## EL PASO COUNTY GRADING AND EROSION CONTROL PLAN CHECKLIST

EPC Project Number: SF2315

SHEET TITLE:
GRADING AND EROSION CONTROL PLAN

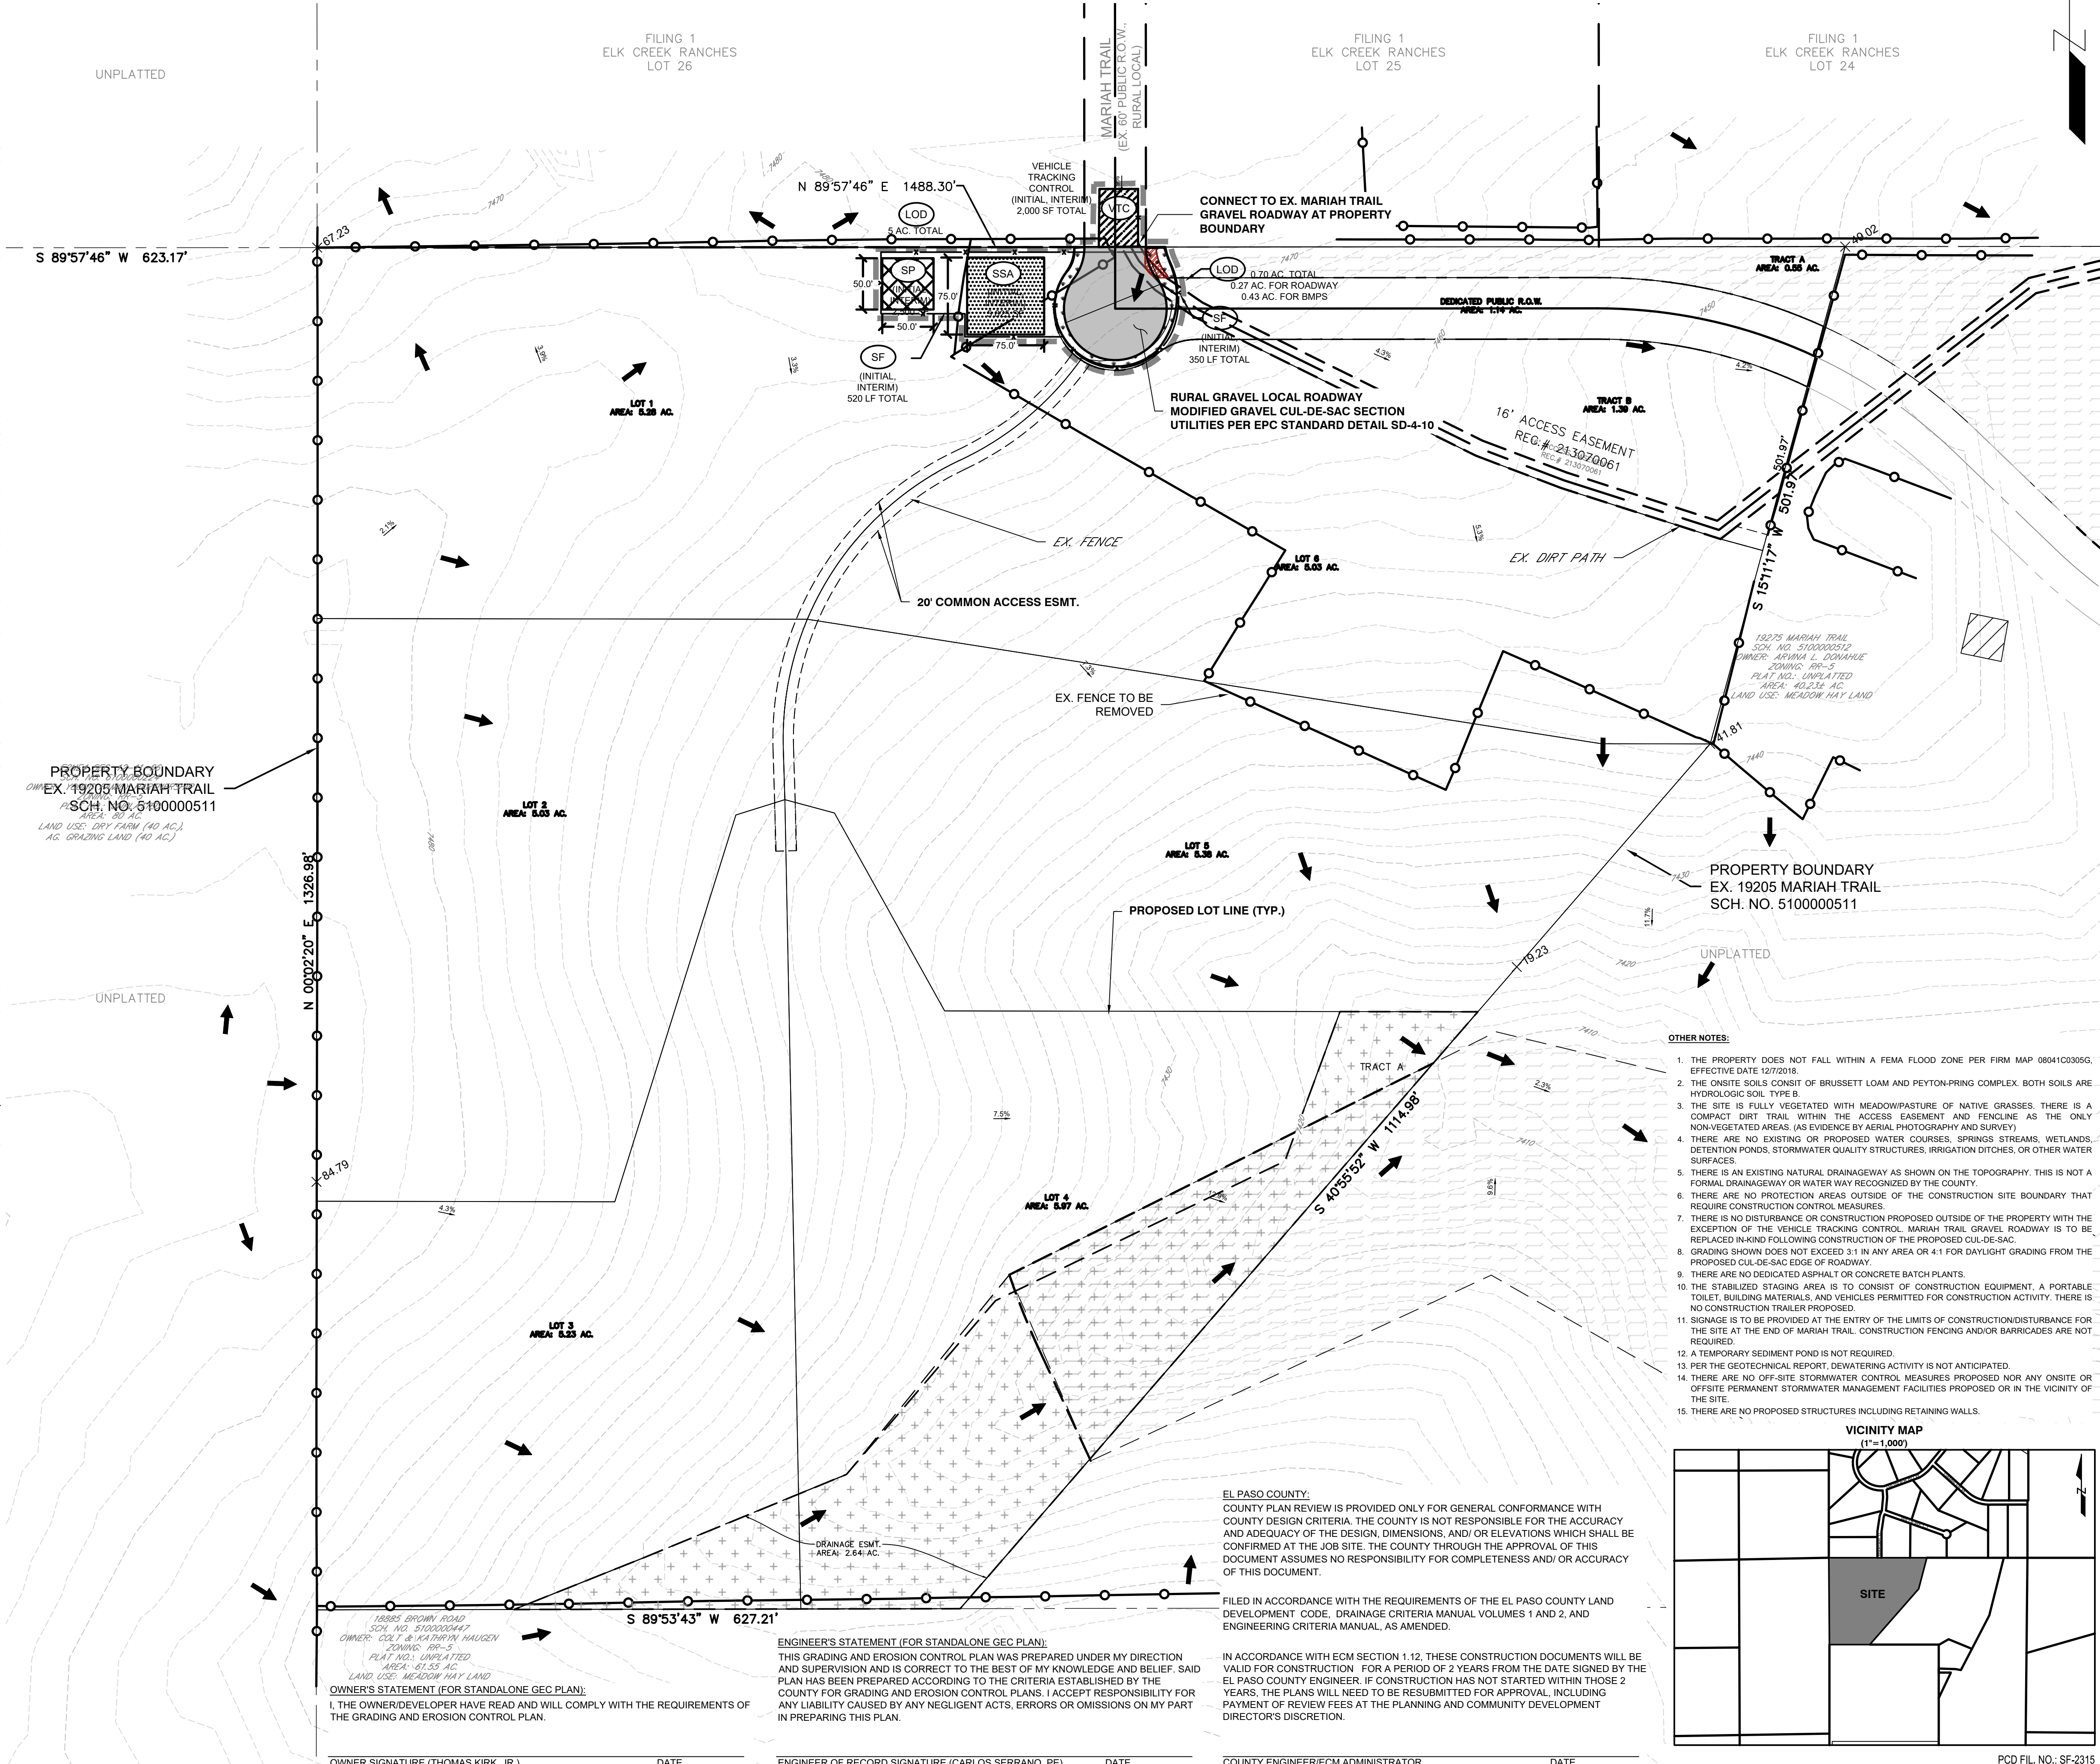
Applicant	EPC
<b>1. GRADING AND EROSION CONTROL PLAN</b> (complete form using Y, N, N/A in the "Applicant" column)			
a	Vicinity map		Y
b	Adjacent city/town/jurisdictional boundaries, subdivision names, and property parcel numbers labeled		Y
c	North arrow and acceptable scale (1"=20' to 1"=100')		Y
d	Legend for all symbols used in the plan		Y
e	Existing and proposed property lines. Proposed subdivision boundary for subdivision projects		Y
f	All existing structures		Y
g	All existing utilities		Y
h	Construction site boundaries		Y
i	Existing vegetation (notes are acceptable in cases where there is no notable vegetation, only grasses/weeds, or site has already been stripped)		Y
j	FEMA 100-yr floodplain		N/A
k	Existing and proposed water courses including springs, streams, wetlands, detention ponds, stormwater quality structures, roadside ditches, irrigation ditches and other water surfaces. Show maintenance of pre-existing vegetation within 50 feet of a receiving water <span style="border: 1px solid black; padding: 2px 5px;">Show RPA areas.</span>

v	All proposed temporary construction control measures, structural and non-structural. Temporary construction control measures shall be identified by phase of implementation to include "initial," "interim," and "final" or shown on separate phased maps identifying each phase		Y
w	Vehicle tracking provided at all construction entrances/exits. Construction fencing, barricades, and/or signage provided at access points not to be used for construction		Y
x	Temporary sediment ponds provided for disturbed drainage areas greater than 1 acre		N
